## Application by The Droves Solar Farm Limited for The Droves Solar Farm

### The Examining Authority's written questions and requests for information (ExQ1): Issued on 13 May 2026

Document reference: APP/6.3.2 (Revision 2)

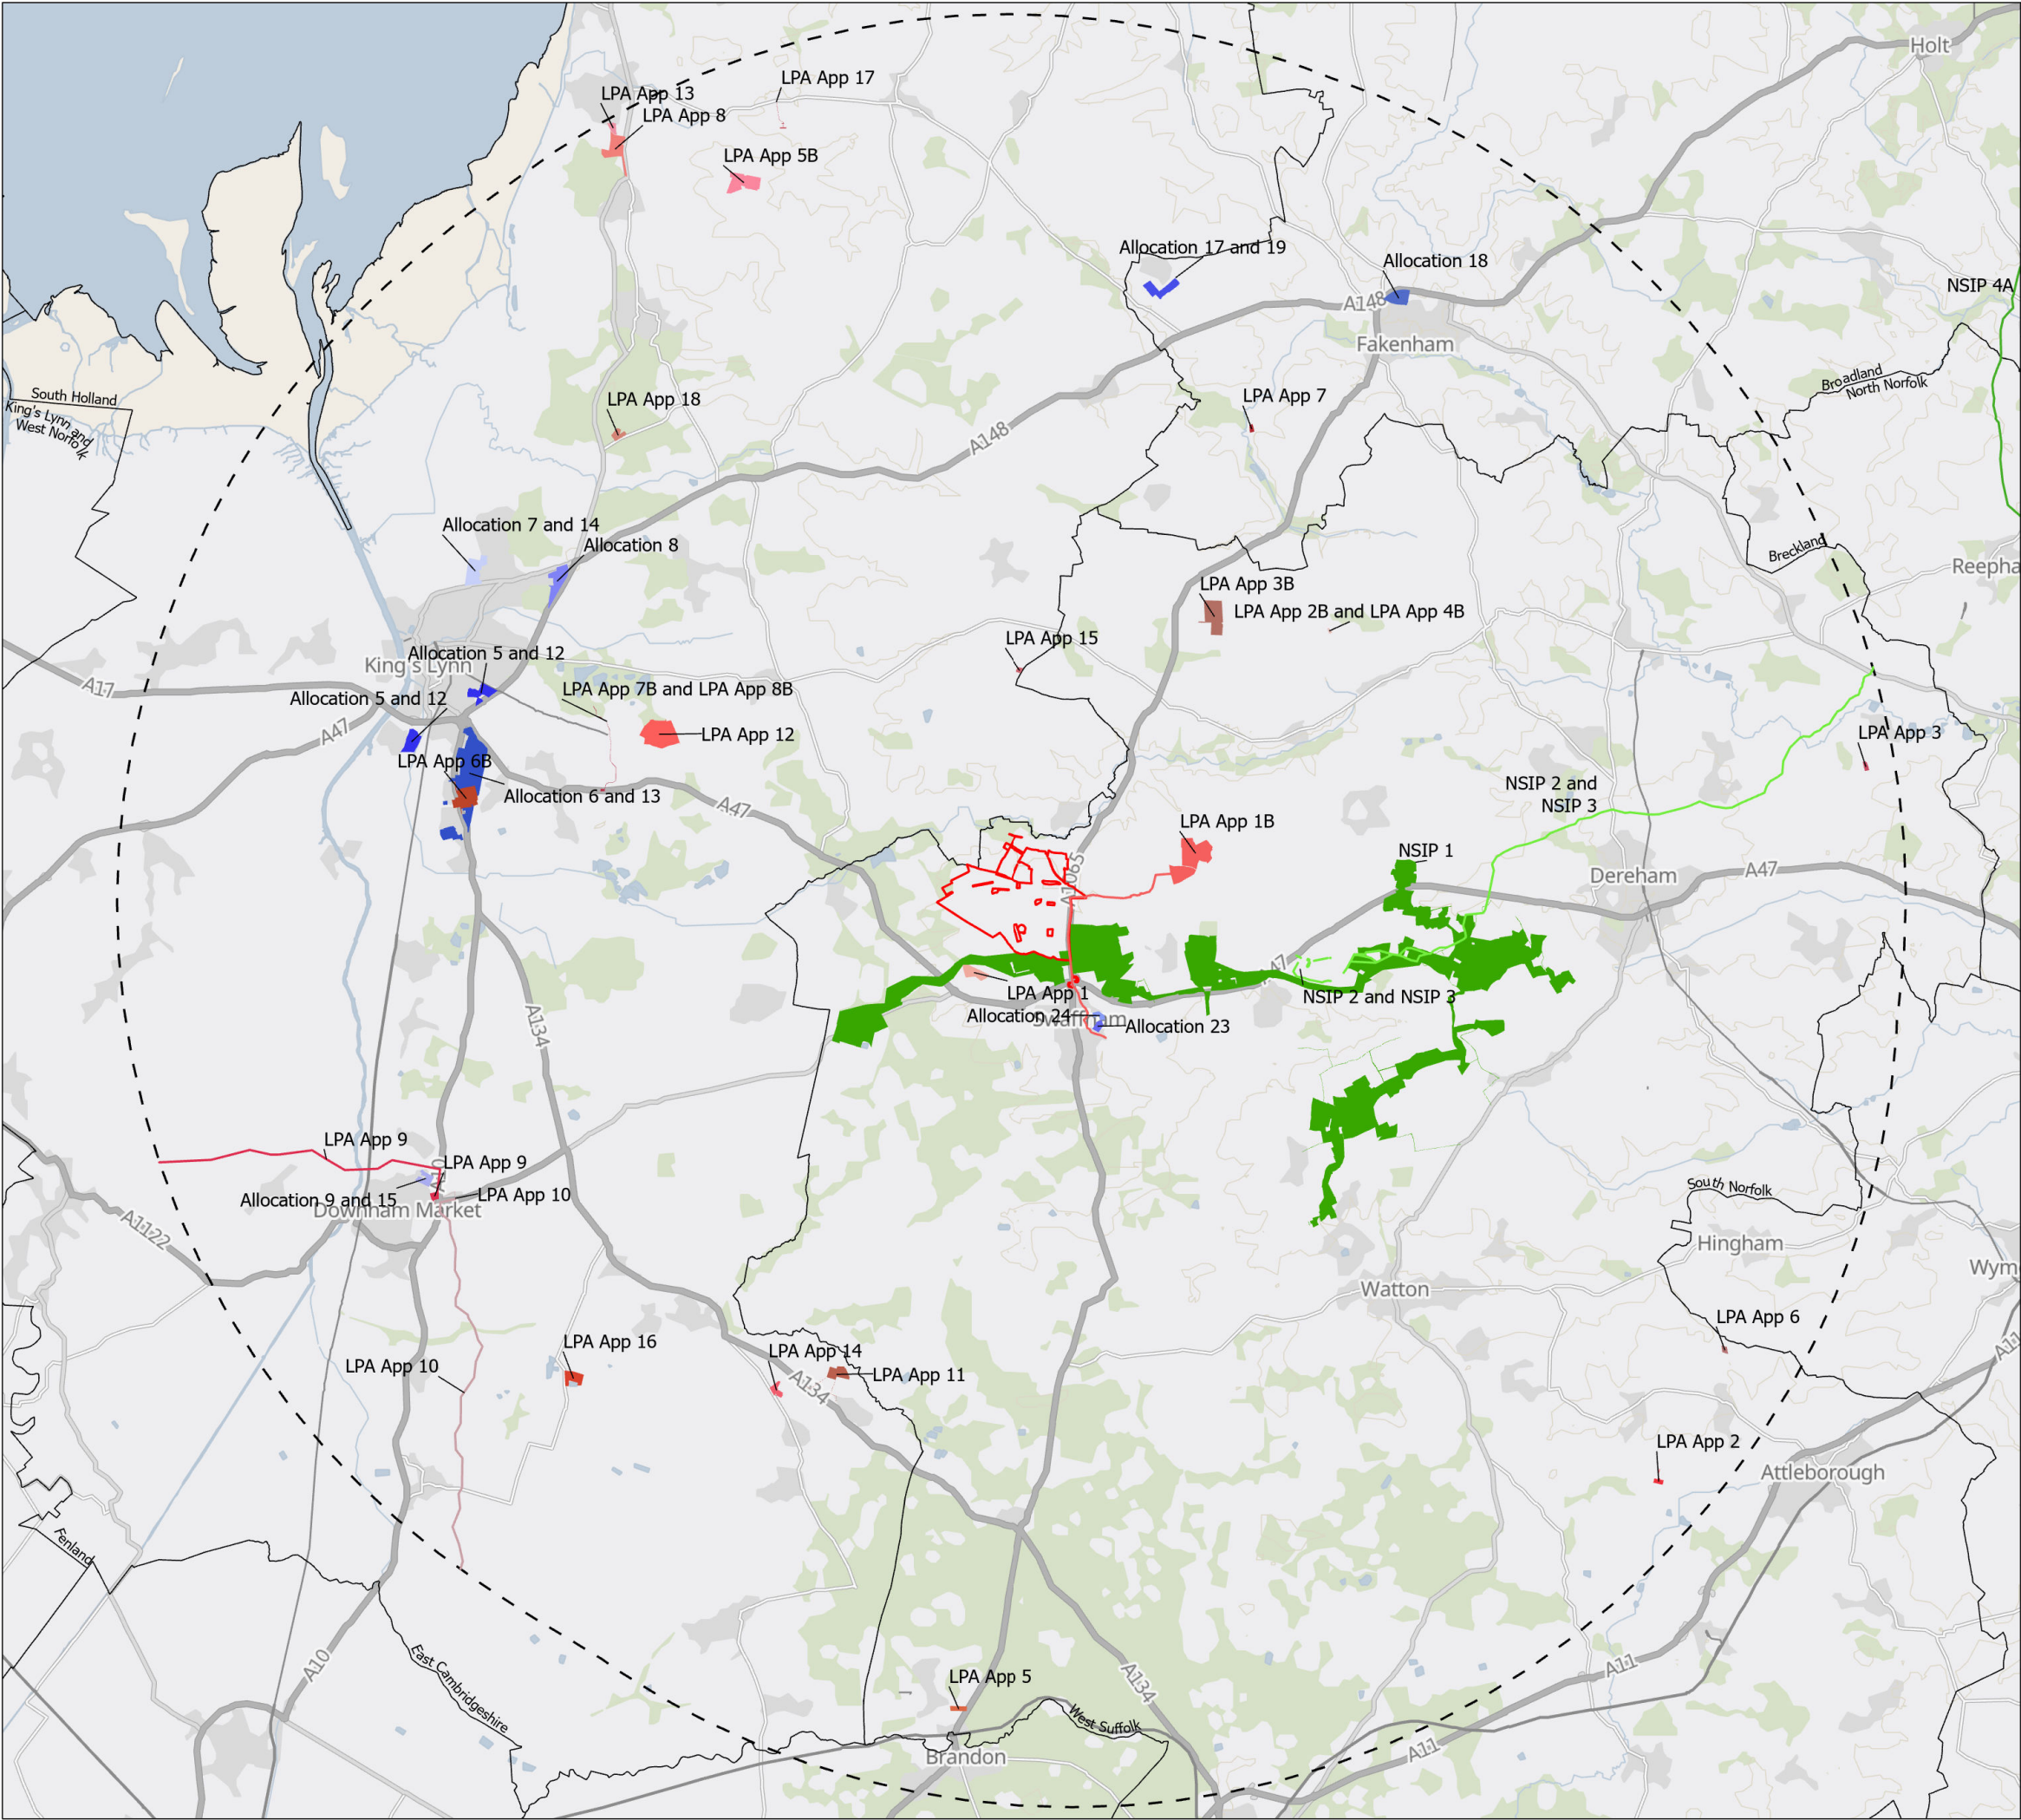
ExQ1	Question to:	Question:
<b>1. General and cross-topic questions</b>		
Q1.0.1	The applicant	<p><b>Environmental Statement (ES) Figure 2.1: Cumulative Schemes</b></p> <p>Figure 2.1 [APP-068] shows there is an overlap of the proposed development's Order limits with the short list of cumulative schemes. Could the applicant update Figure 2.1 to annotate clearly each scheme from the short list (to include High Grove Solar Farm) and provide details of any interaction or overlaps.</p>
Q1.0.2	The applicant	<p><b>Community Benefits</b></p> <p>With reference to the Consultation Report [APP-025], Table 22 states: <i>"Throughout the pre-application process, the Applicant has consulted on community benefits and, based on feedback and ongoing discussions, will determine how best to distribute funding."</i></p> <p>Could the applicant clarify what community benefits are proposed and how these would be secured?</p>
